Date: 13 June 2024
Our ref: 472774
Your ref: EN010122

NSIP Reference Name / Code: Oaklands Farm Solar Park / EN10122

Title: Natural England's comments in respect of Oaklands Farm Solar Park, promoted by BayWa.

Figure 15.1: Agricultural Land Classification Results

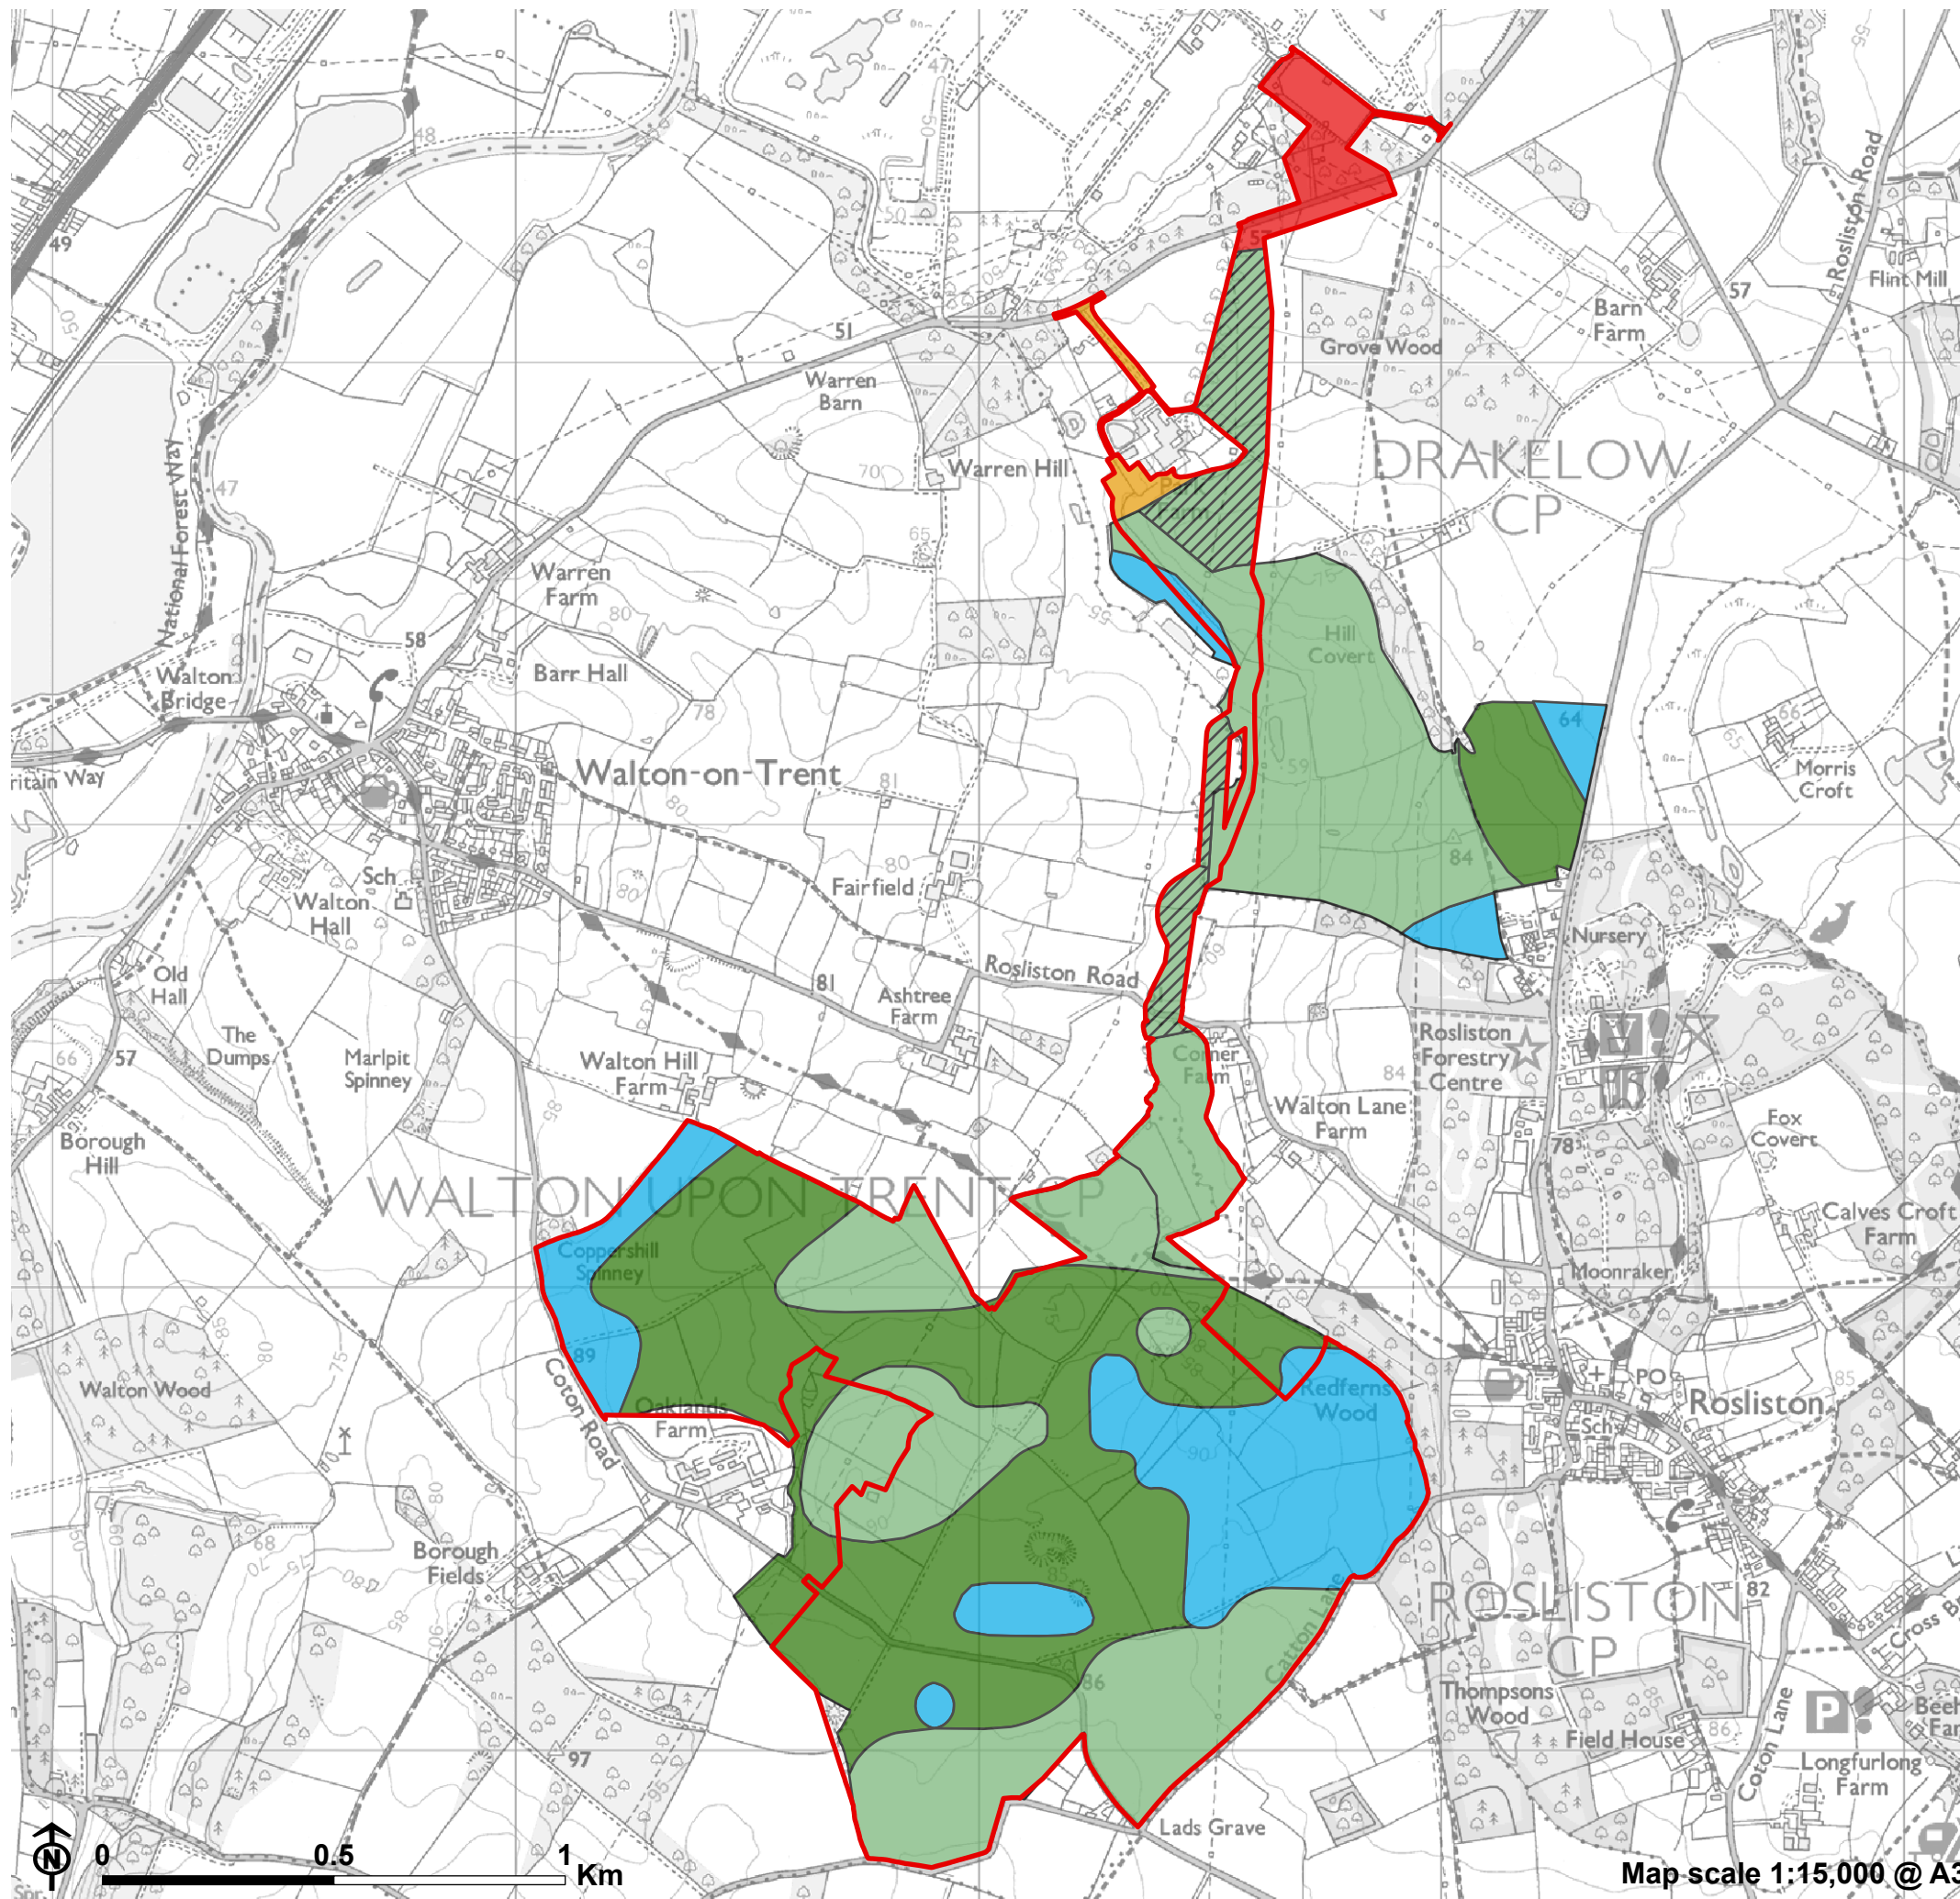
Plate 15.3 This map identifies land outside of the DCO as mostly non BMV but with 2 and 3a BMV present. Natural England request clarification as to whether this land has undergone detailed survey.

15.91 Natural England does not concur with the assumption land quality is mostly 3b within the cable route corridor. Grading should be based on actual findings from an ALC survey.

Drawing Title: ALC Grade

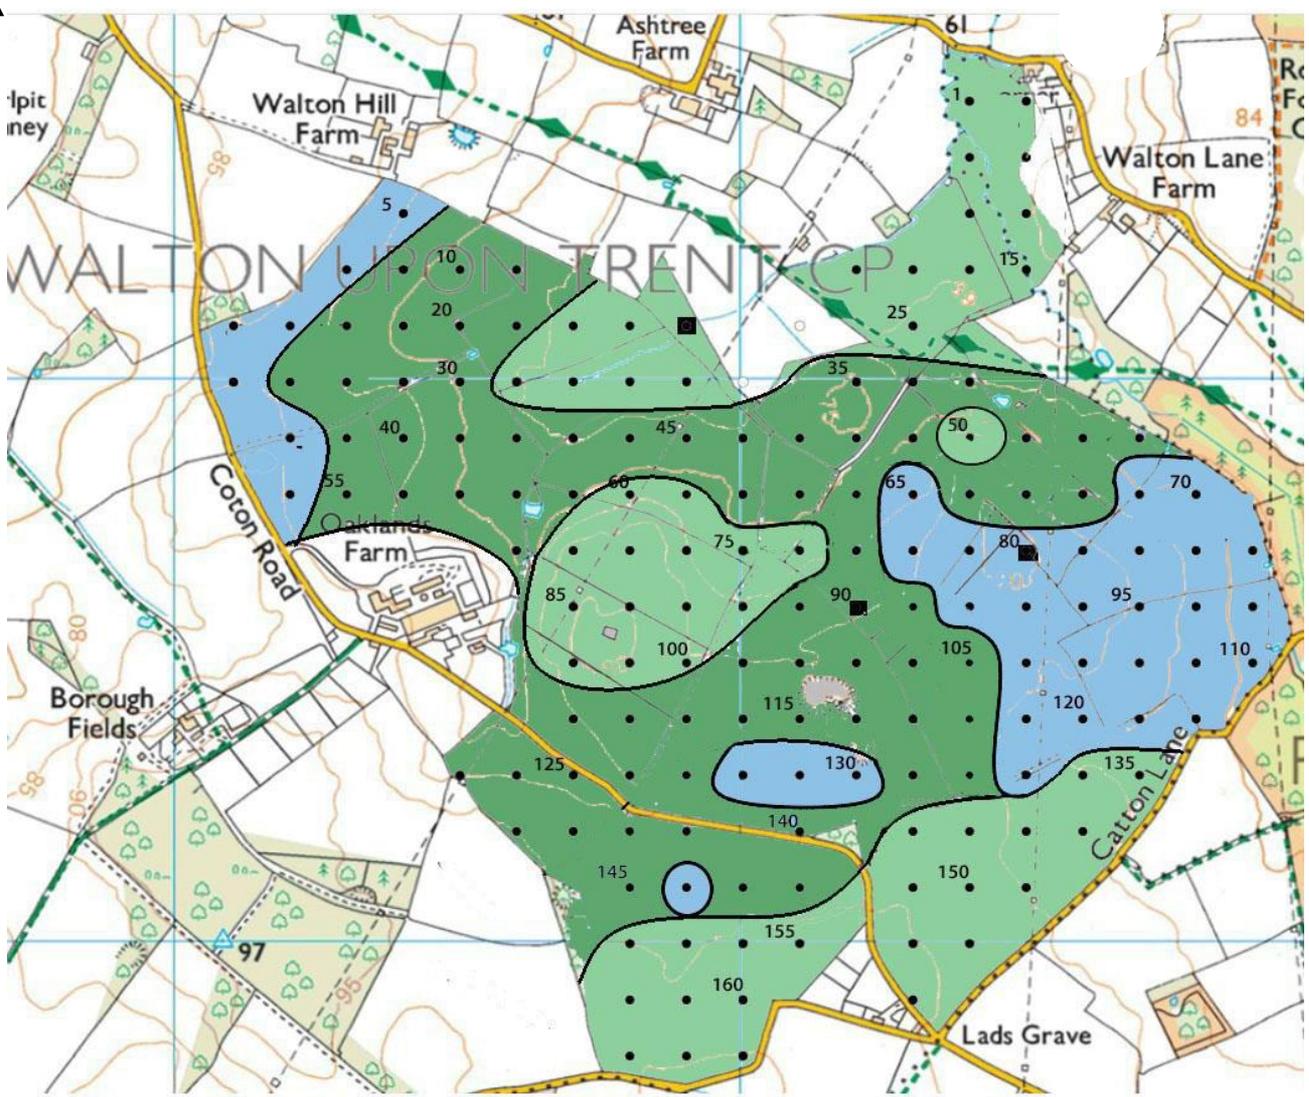
Pits 80 and 90 are clearly indicated on the Drawing No.: 1 however the presented soil profile data does not clearly identify numbered pits.

**Plan KCC3018/01B**  
**Auger Point Plan**

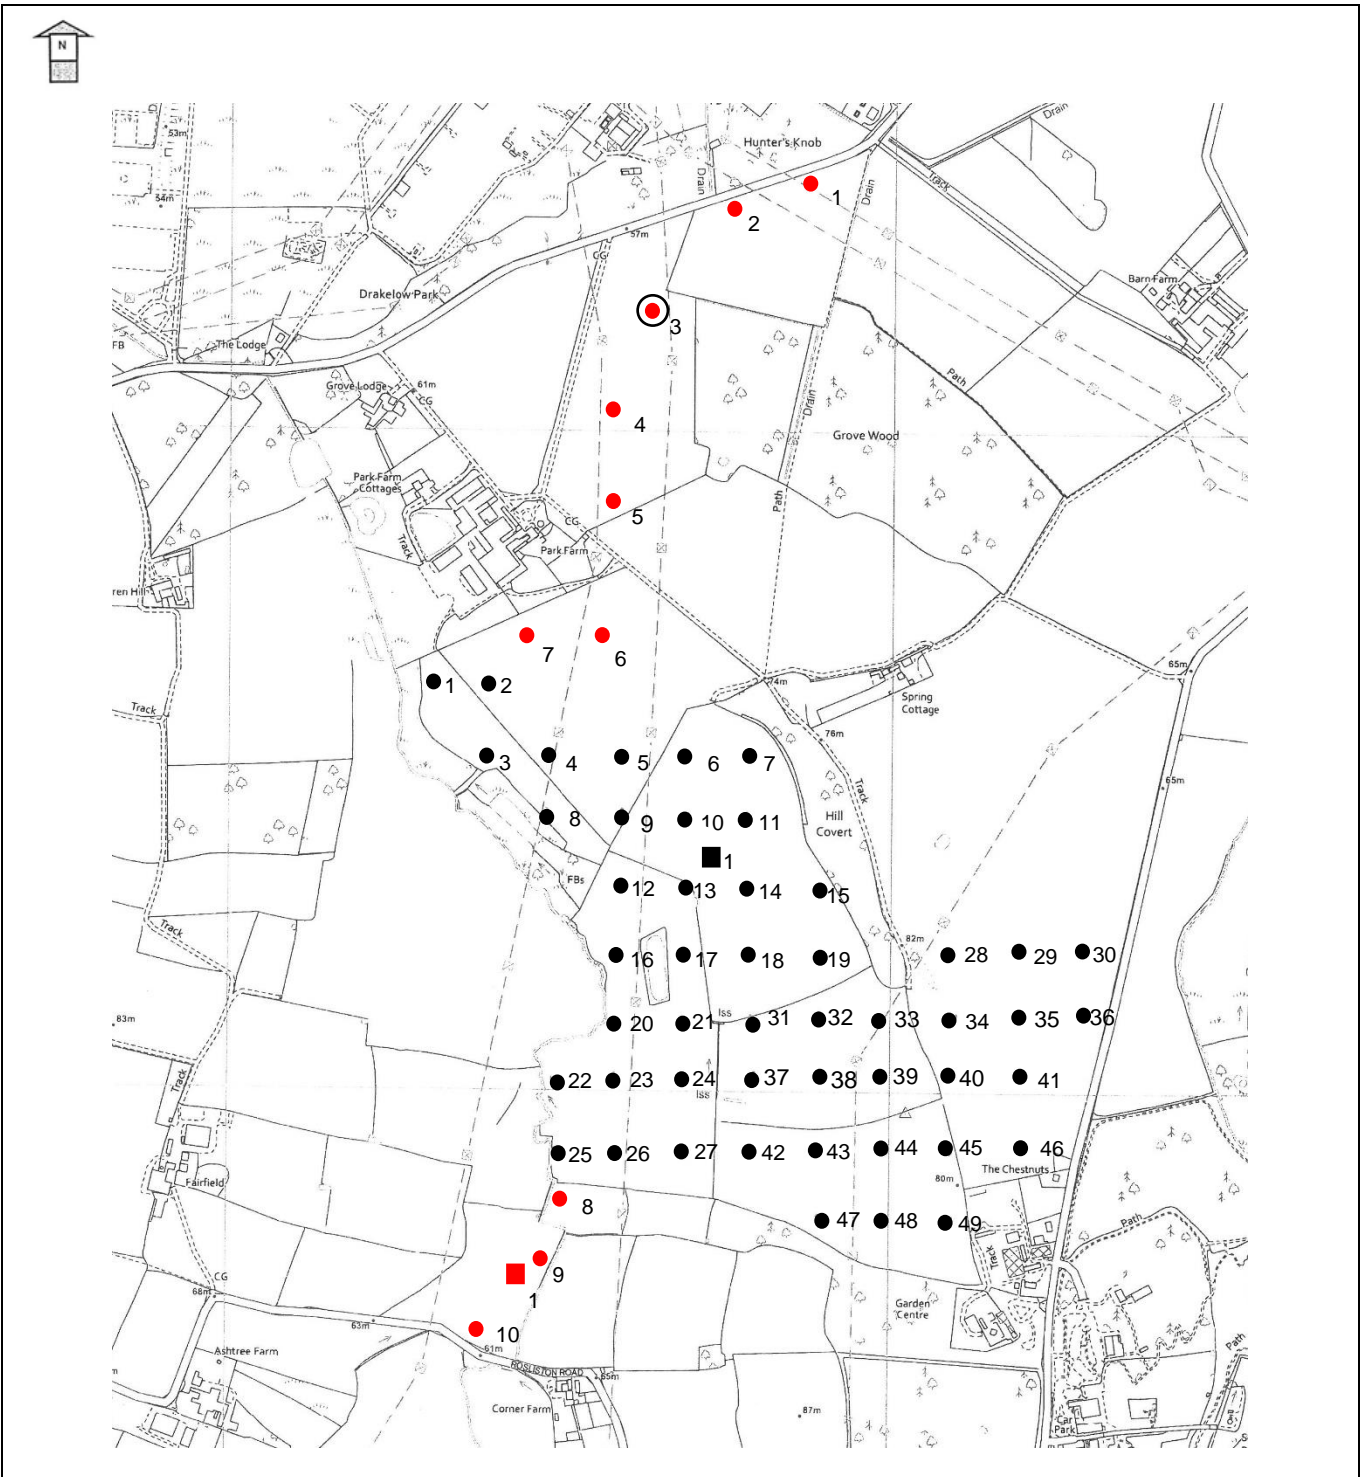
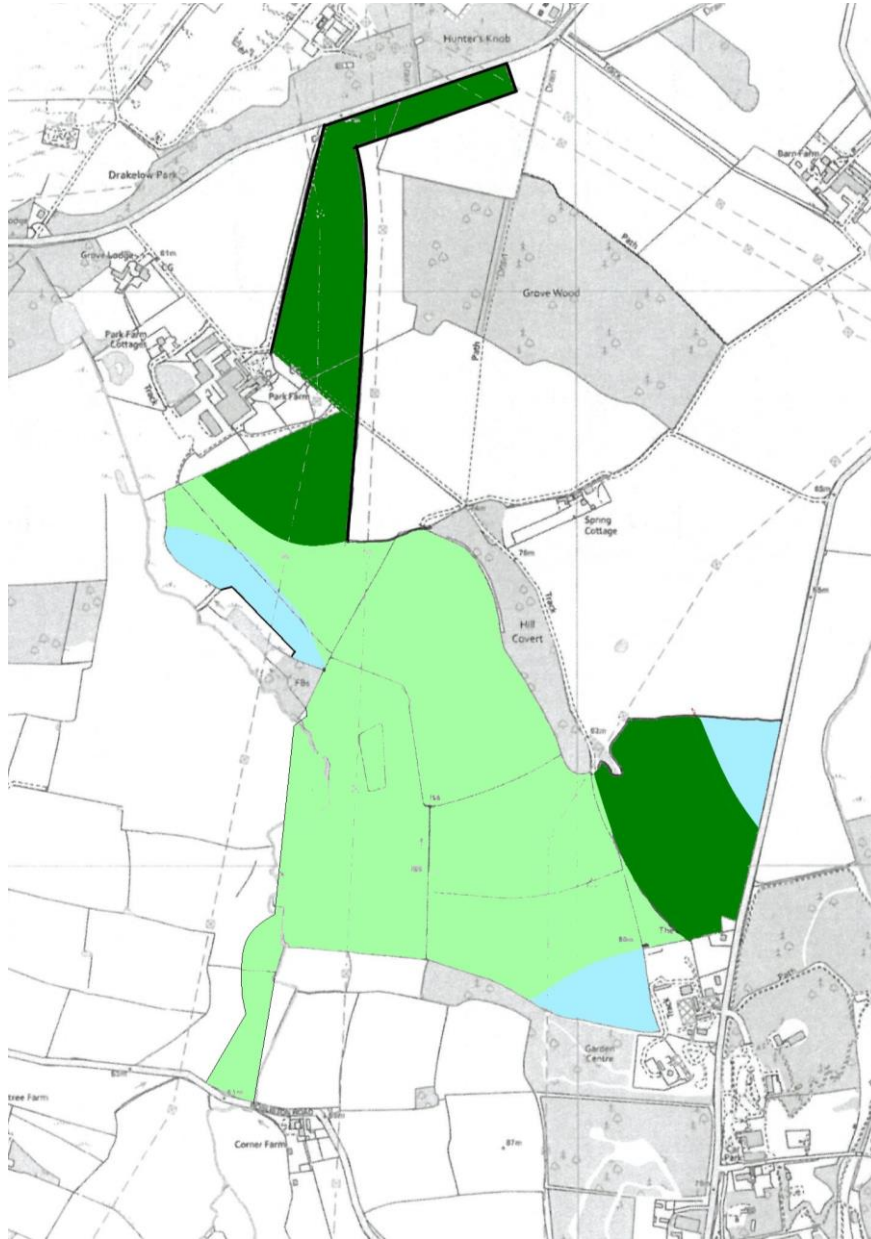
2.4 Pit 1 is not visible on plan KCC3018/01A therefore, Natural England is unable to verify to location of pit 1 or confirm the observations made at that sample location.

3.16 Auger borings 34, 35, 36, 40 and 41 are not visually represented on plan KCC3018/01A or presented in soil profile log data.
